12710 Sylvan Meadows Drive, Vacation of No-Build, VR-20-5

Please accept the following comments from El Paso County Public Health for the plat amendment request referenced above:

ELEVATIONS

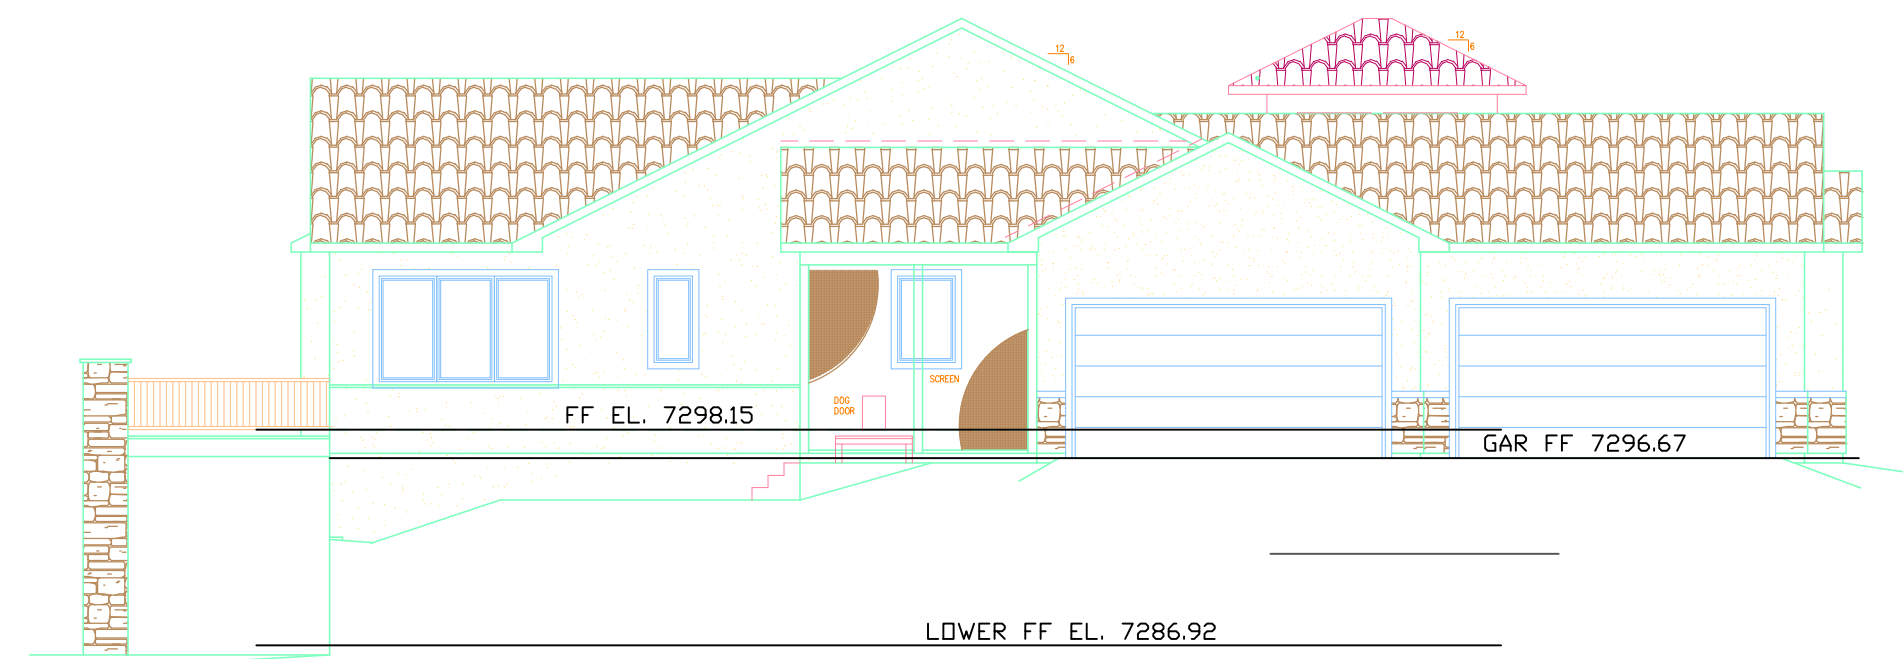
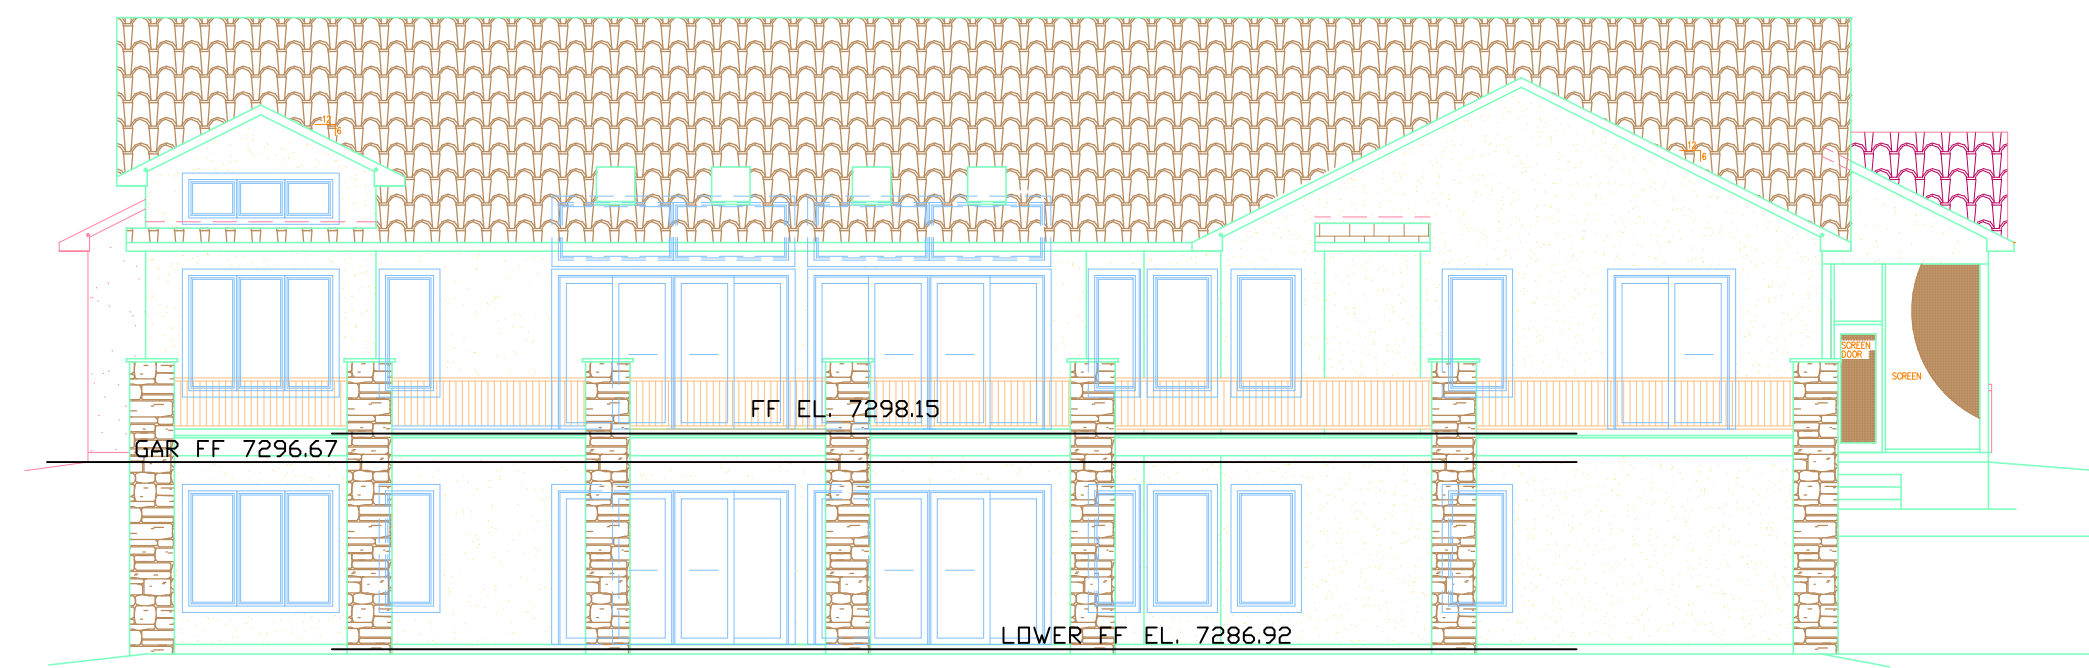
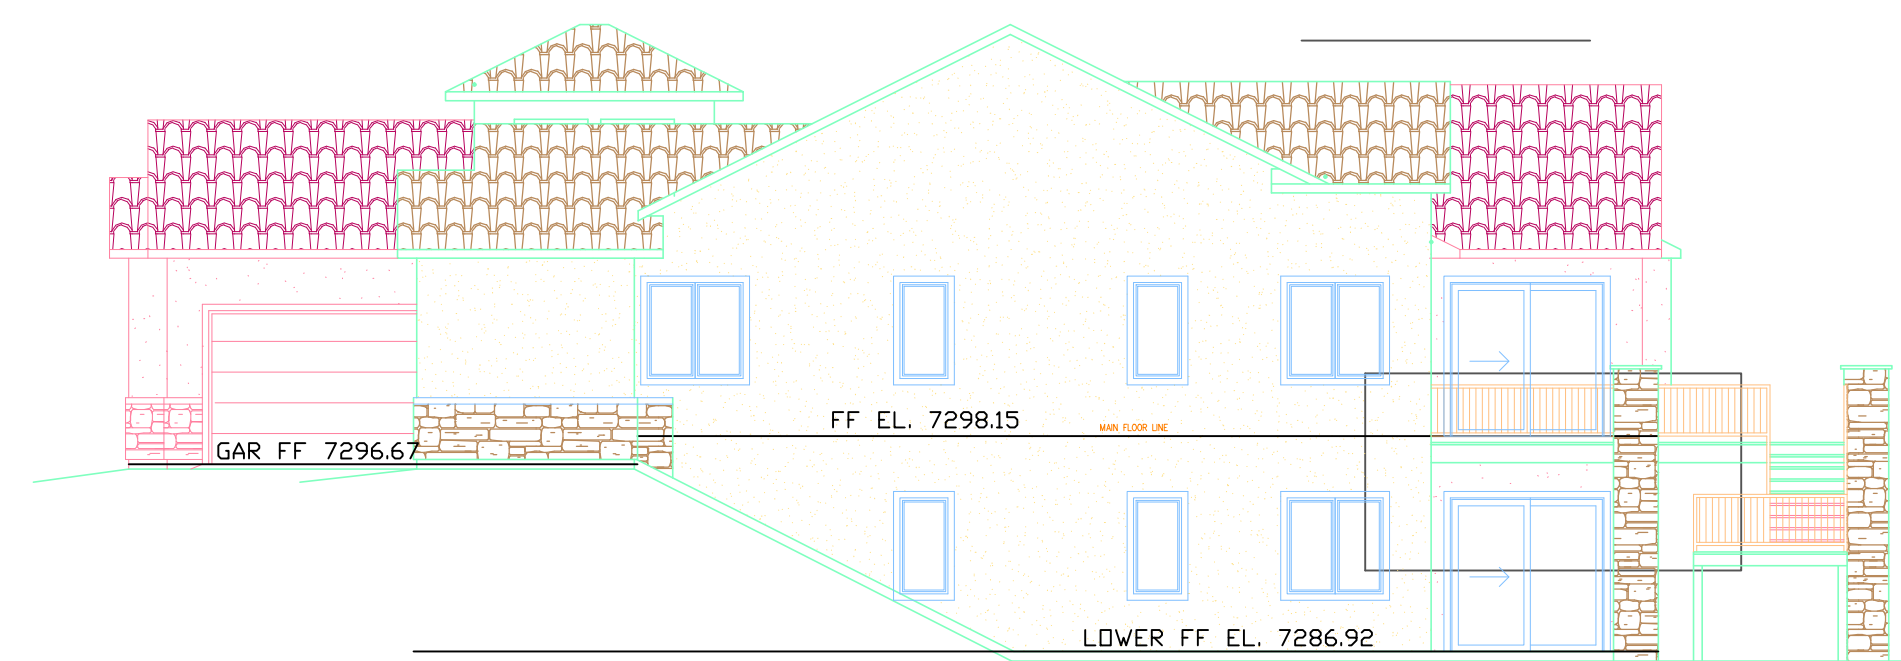
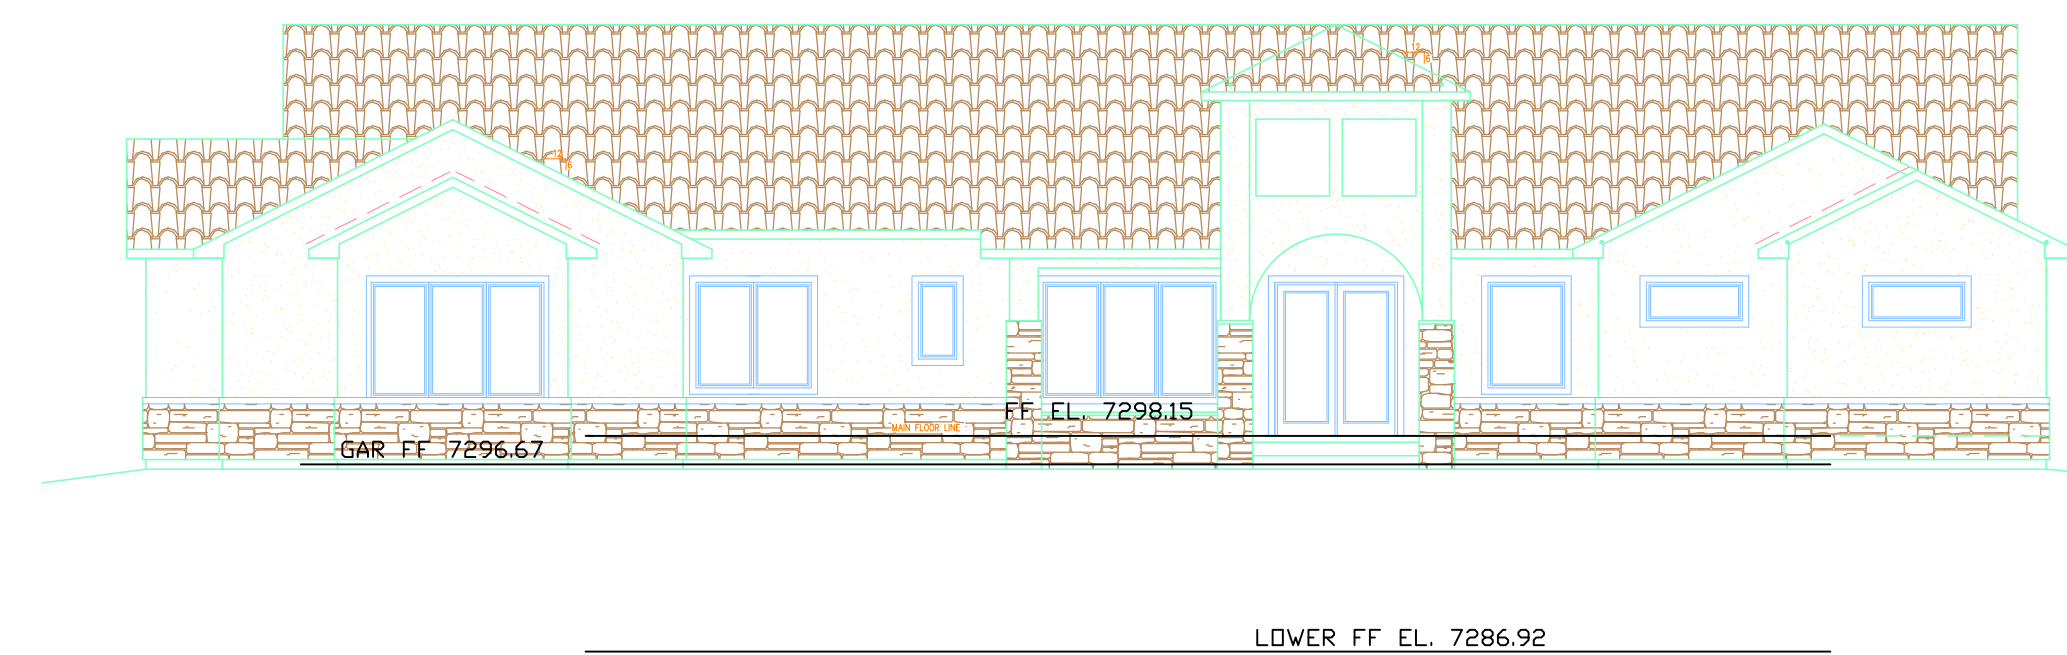
- **Water service for the lot will be by an individual private well. The location of the well must be a minimum of 100' from the closest portion of the proposed onsite wastewater treatment system (OWTS) primary and secondary soil treatment areas, and from any neighboring OWTS.**

- **Wastewater service for the 5.002-acre lot is planned to be provided by an OWTS. Approval of a New OWTS Permit located per the plot plan submitted with this request, is dependent on the approval of this Vacation of No-Build request. Based on the 26Nov2018 Entech Engineering, Inc., soils testing report, the Plot Plan submitted by Oliver E. Watts, Consulting Engineer, and the 05June2020 No-Build Area revised plan from Oliver E. Watts, El Paso County Public Health has no objection to the proposed house location.**

- **The primary and secondary OWTS soil treatment areas (STA) of the future OWTS must be protected from all vehicular traffic or any activity that will subject the STA's to compaction. Should the STA areas be compromised by compaction, then El Paso County Public Health will require the area(s) to be abandoned and new areas with associated soil testing be submitted and approved.**
